Jeanie Bourke  
City of Portland Planning and Urban Development Dept. / Inspections Division  
389 Congress Street, Room 315  
Portland, Maine 04101

April 26, 2013  
Re: Baxter Academy  
54 York Street, Portland, ME  
CBL 042 A0070      Pending Permit #2012-45504

The revised drawings have been sent via email in PDF as per your request. Below are responses to yours and Ben Wallace's review comments.

1hr RATED EXISTING WOOD STUD PARTITION

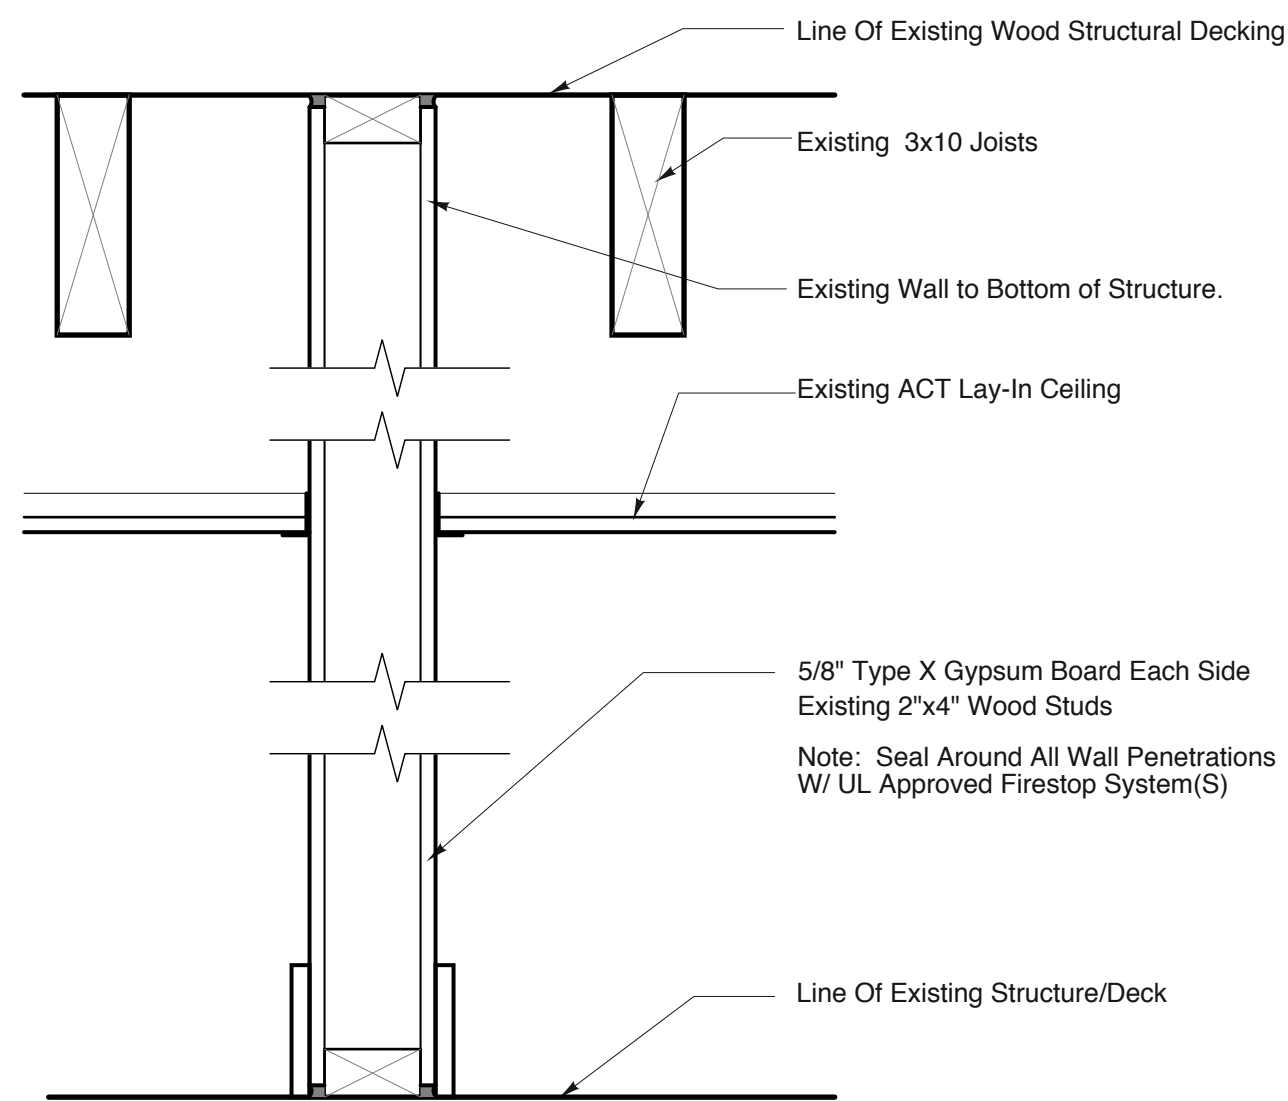
*Q4. No detail similar to "1-hr RATED EXISTING WOOD PARTITION" showing the corridor construction of the smoke partitions in accordance with 101:8.4 (floor to floor or roof deck above or other approved arrangement).*

**A. Refer to revised drawing A1.3 (04-24-13).**

Drawing Title
FIRE PROTECTION
SYSTEM PROPOSAL-
SECOND FLOOR

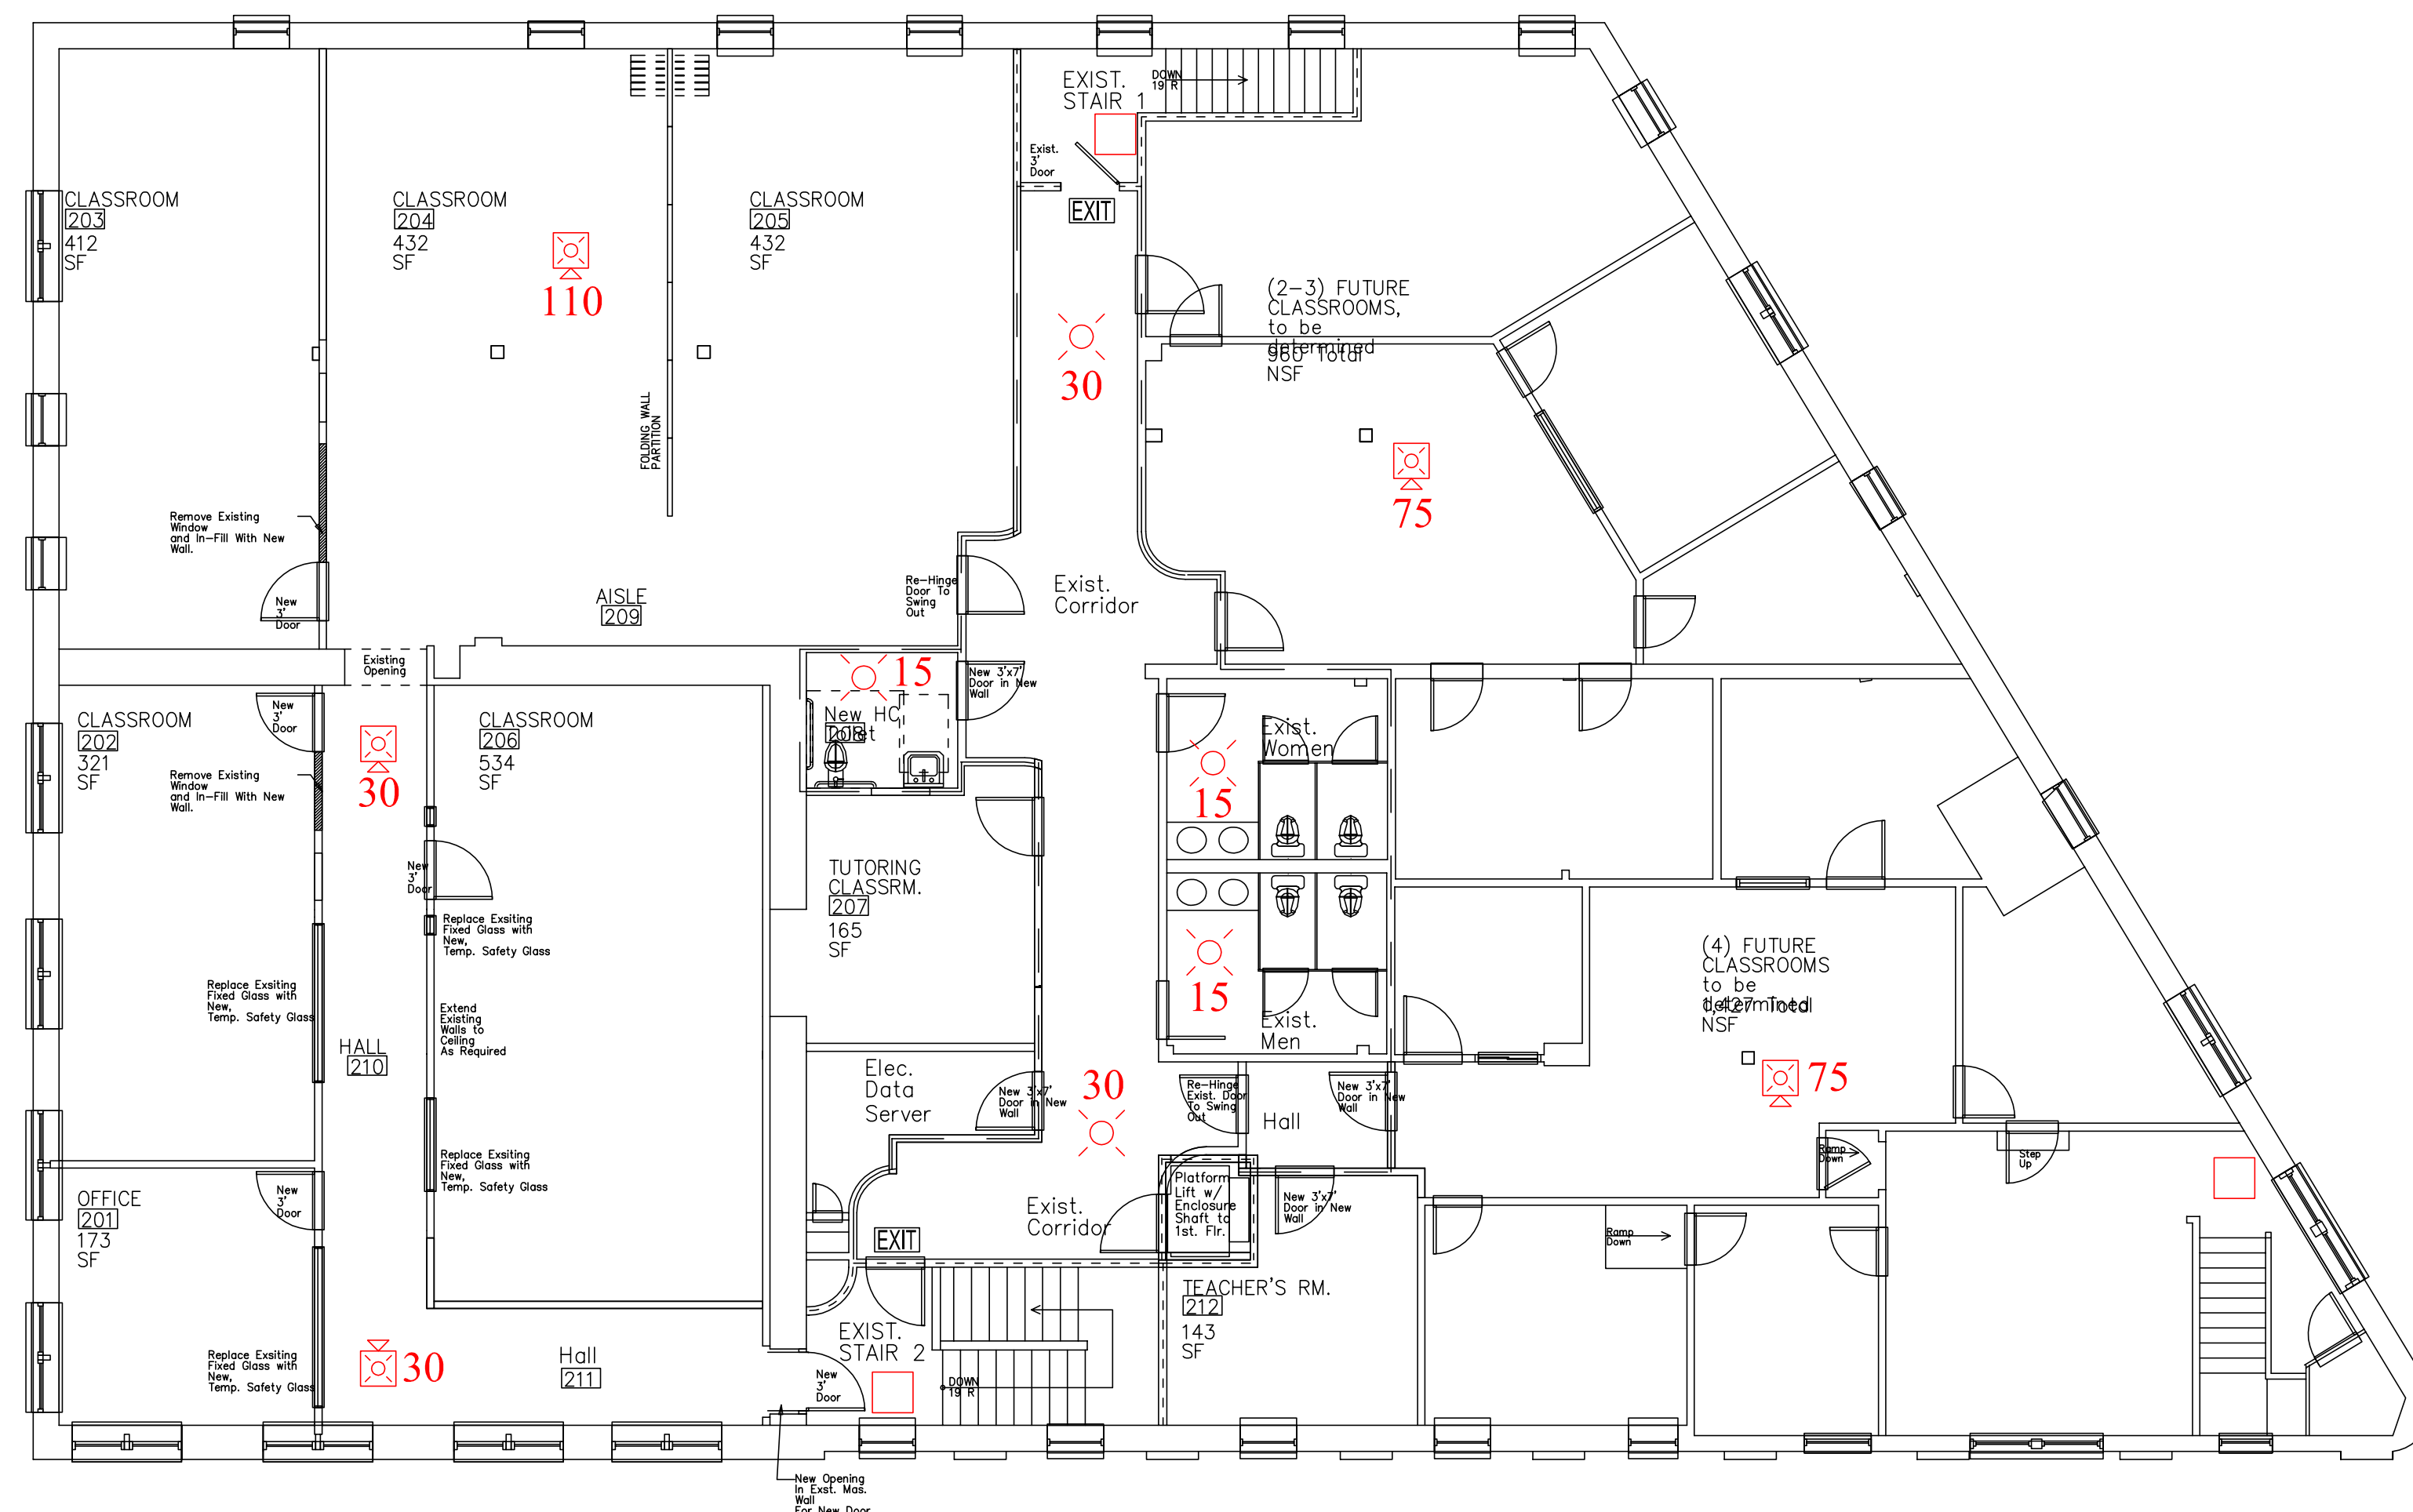
*Q5. The fire alarm plans are incomplete and not correct with regards to strobe placement. I don't review these as a part of the building permit review but I want it to be made known as they will not be considered as a part of the approved plans.*

**A. Revised and corrected fire protection plans are being prepared based on the recent architectural changes and will be re-submitted under separated cover.**
